KITTTAS COUNTY COMMUNITY DEVELOPMENT SERVICES

December 29, 2020

Subject: Forest Ridge Phase 1 (LPF-20-00005) Final Long Plat – Return of Application and Request for Additional Information

FOREST RIDGE - PHASE I PERFORMANCE BASED CLUSTER PLAT		
PREPARED FOR FRPP PHASE I, LLC		
A PORTION OF SECTION 24, TOWNSHIP 20 NORTH, RANGE 15 EAST, W.M.		
KITITAS COUNTY WASHINGTON		
DWN BY	DATE	JOB NO.
T.S.	12/2020	18069
CHKD BY	SCALE	SHEET
M.K.K./D.L.P.	1" = 500'	2 OF 6

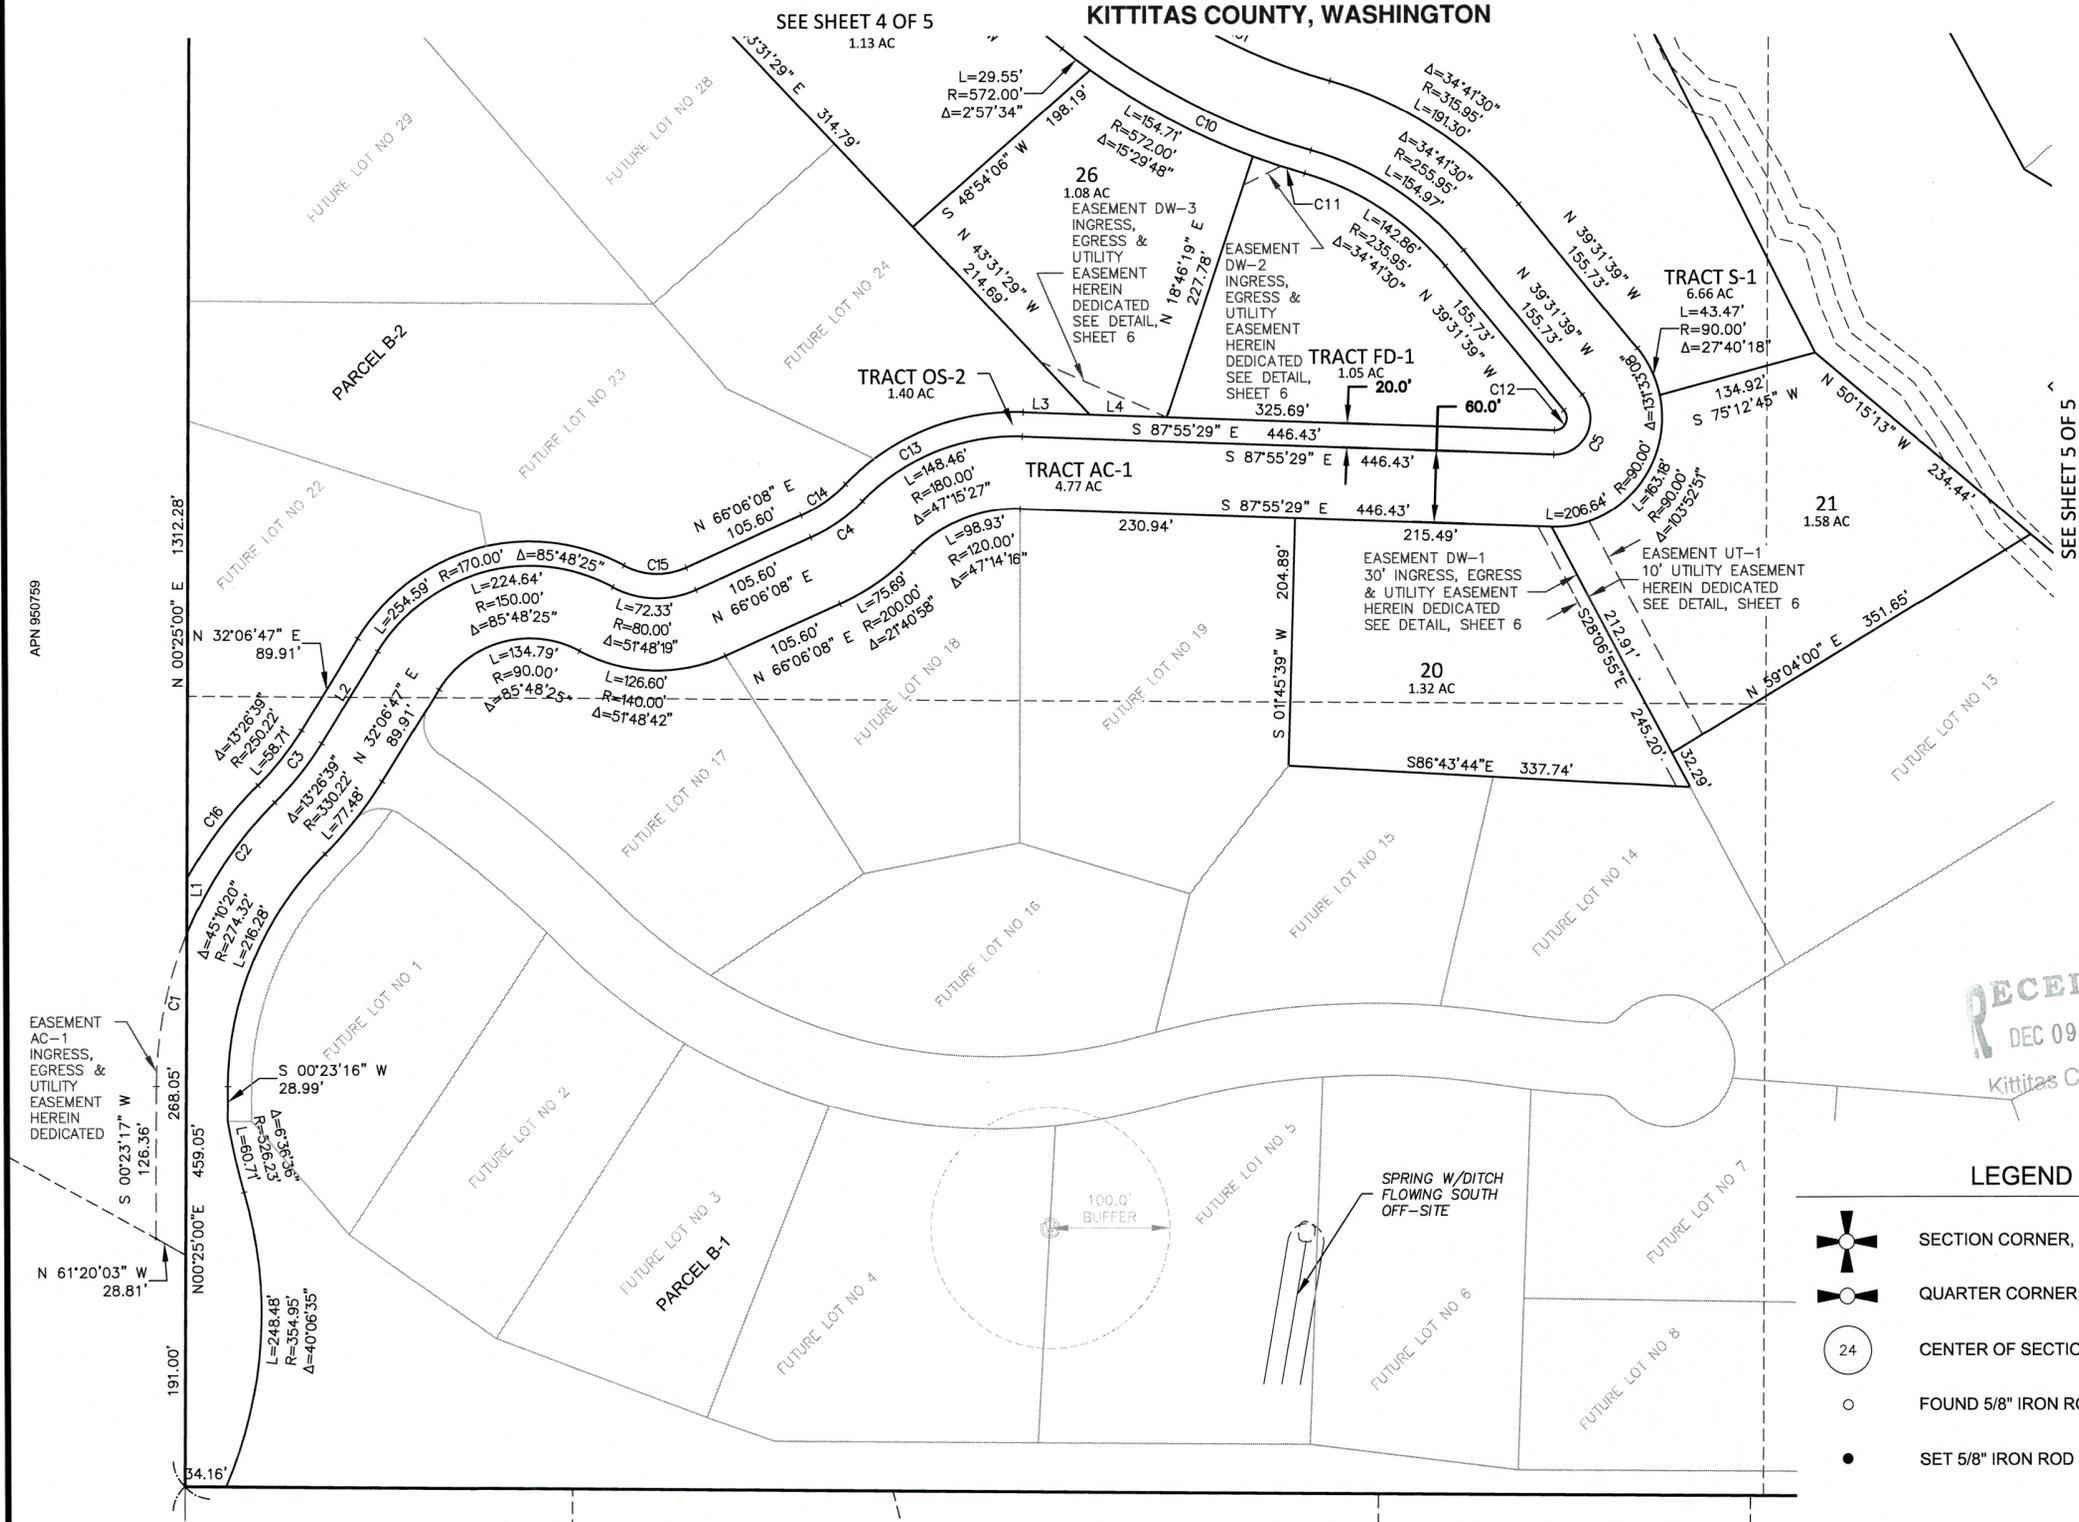
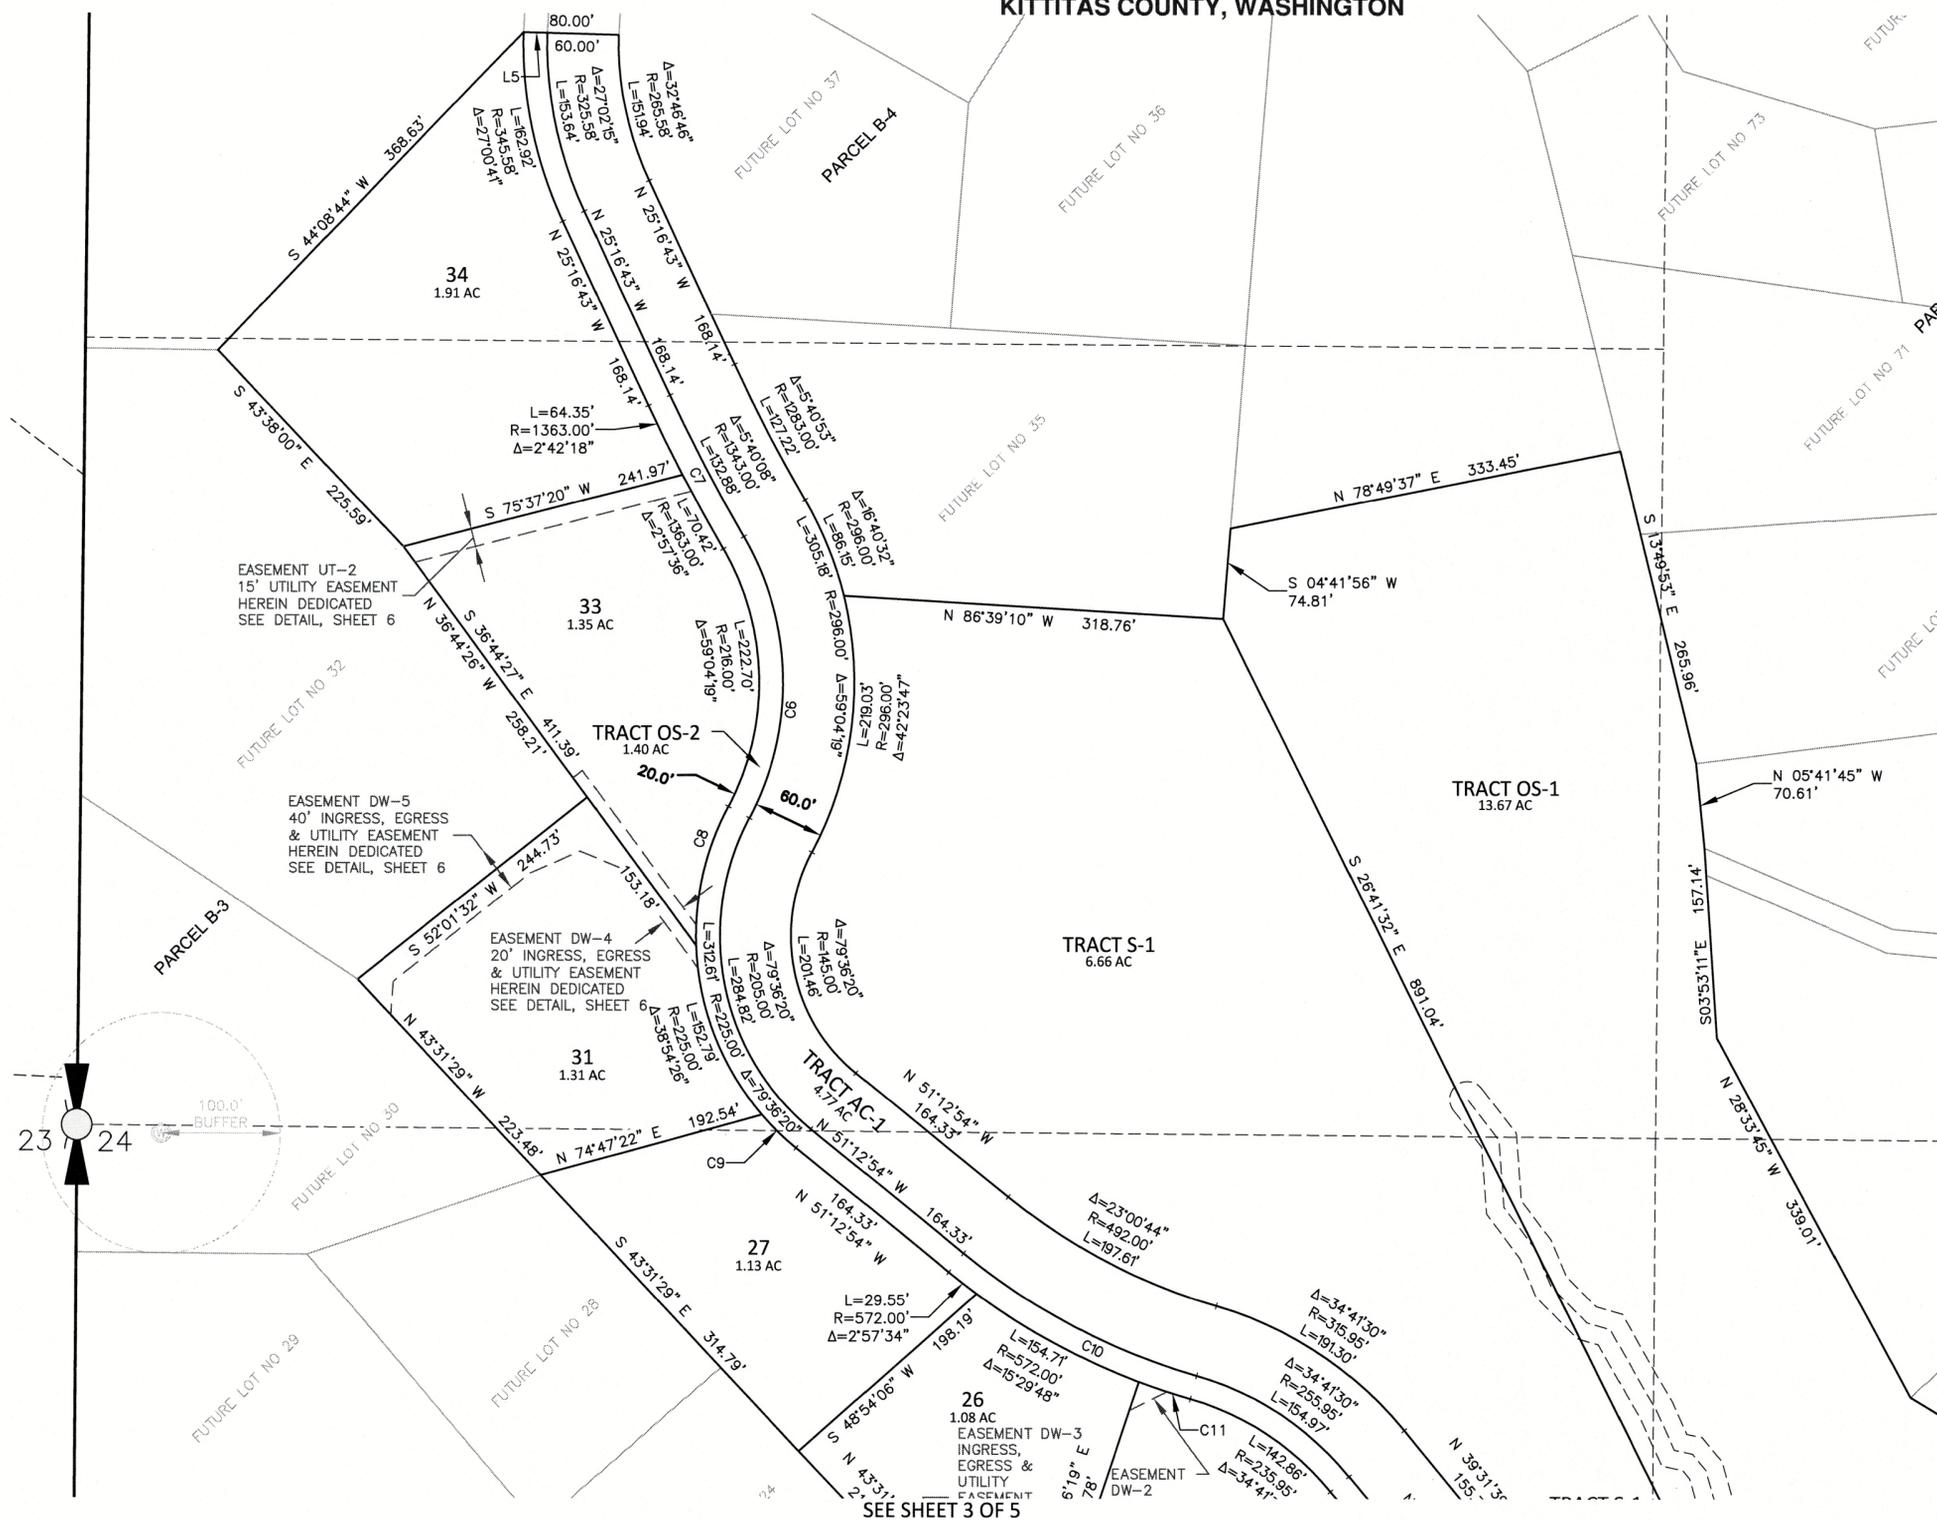
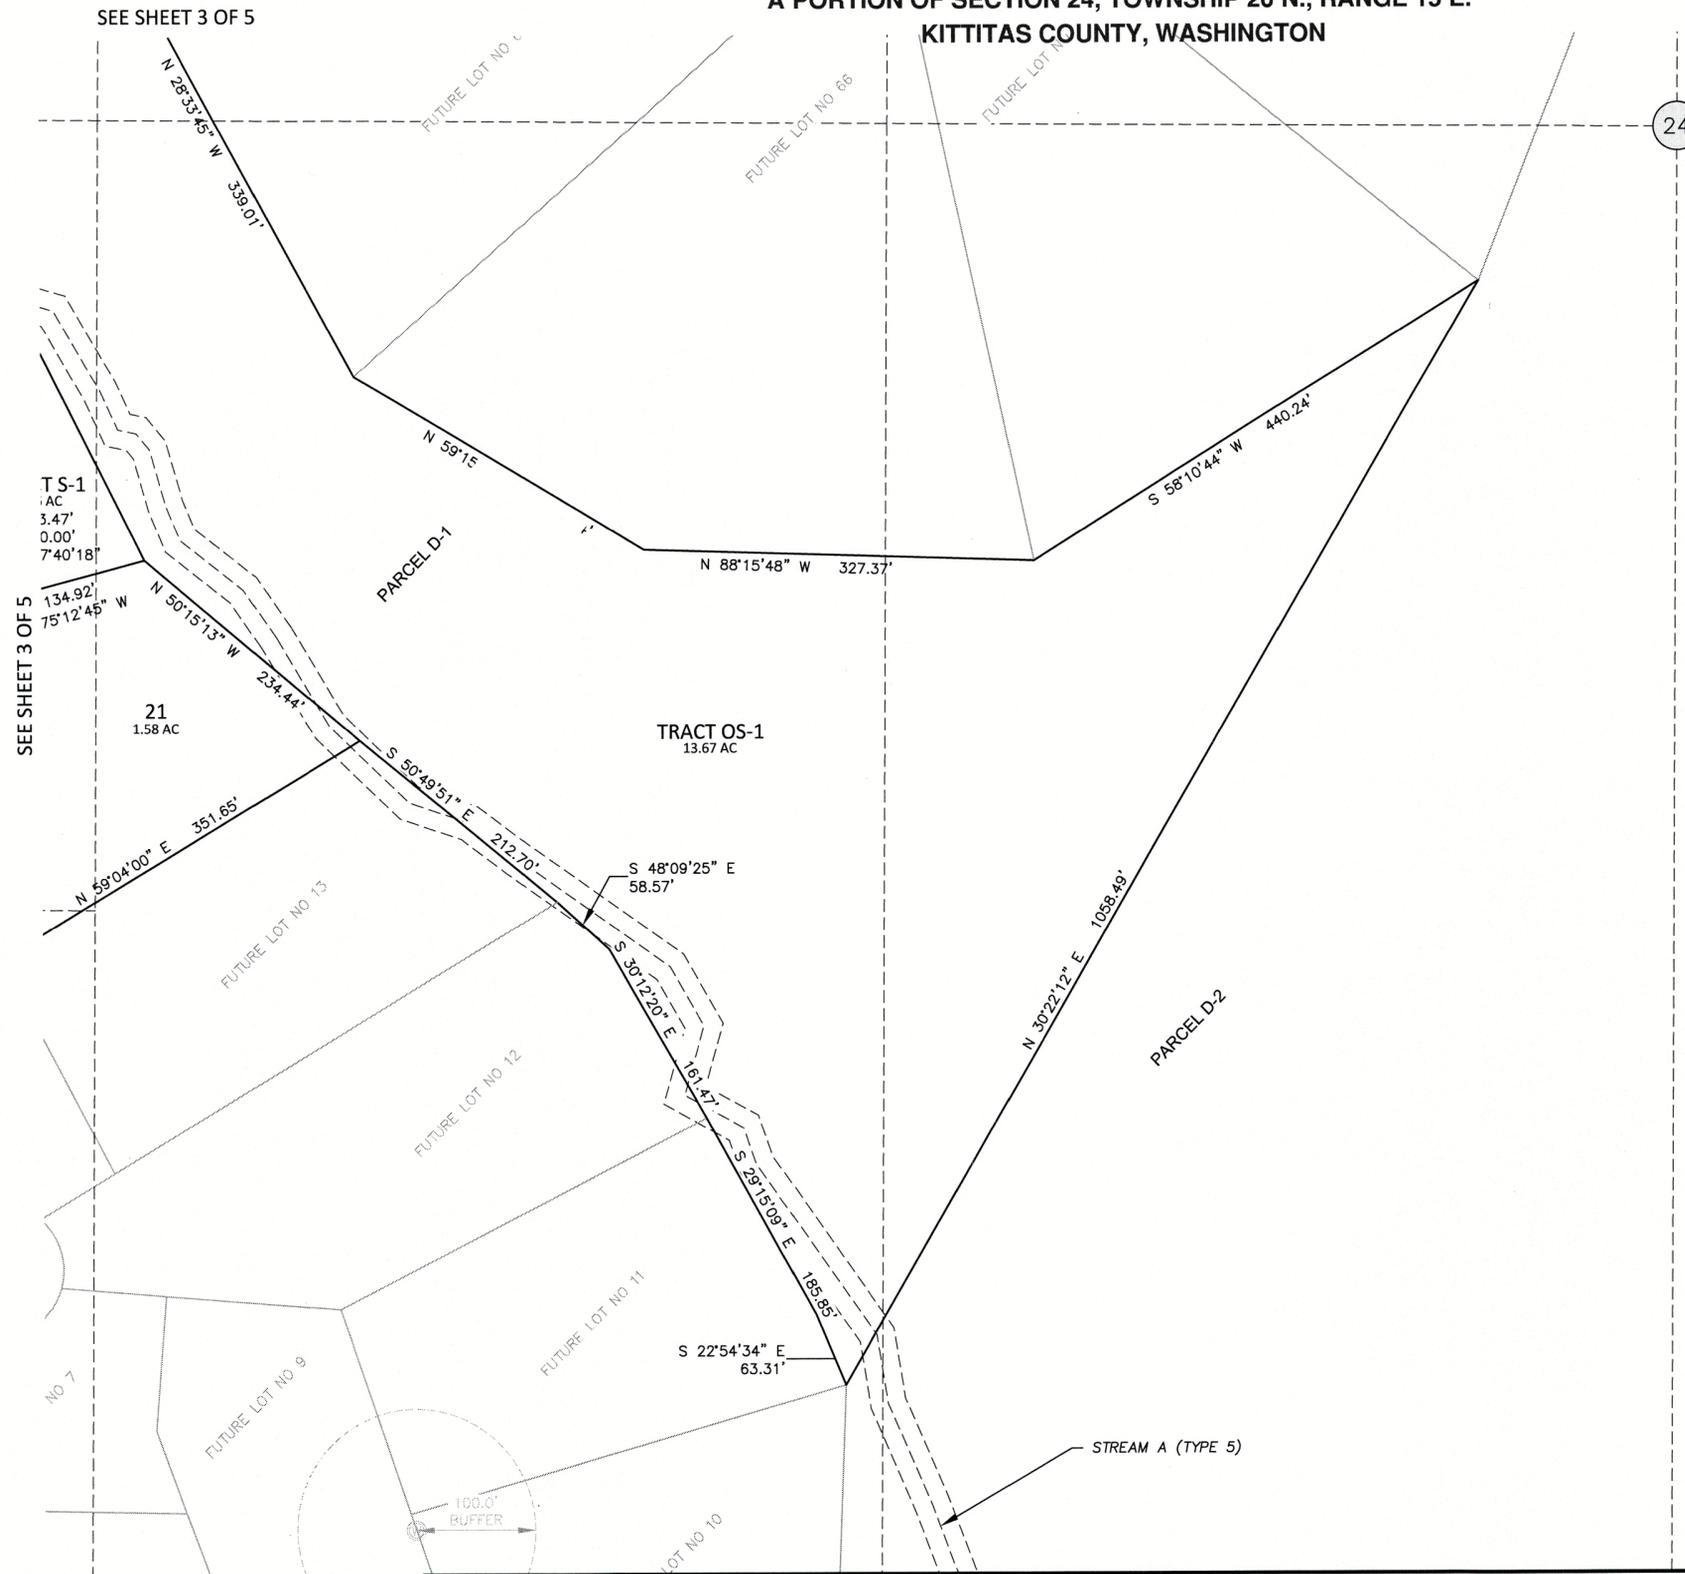
- Wetlands "A" and "B" as depicted on the attached wetland inventory map are not noted on the preliminary survey. Condition #11 of Resolution 2010-137 requires, "All wetland areas and their buffers shall be shown on the face of the final plat."
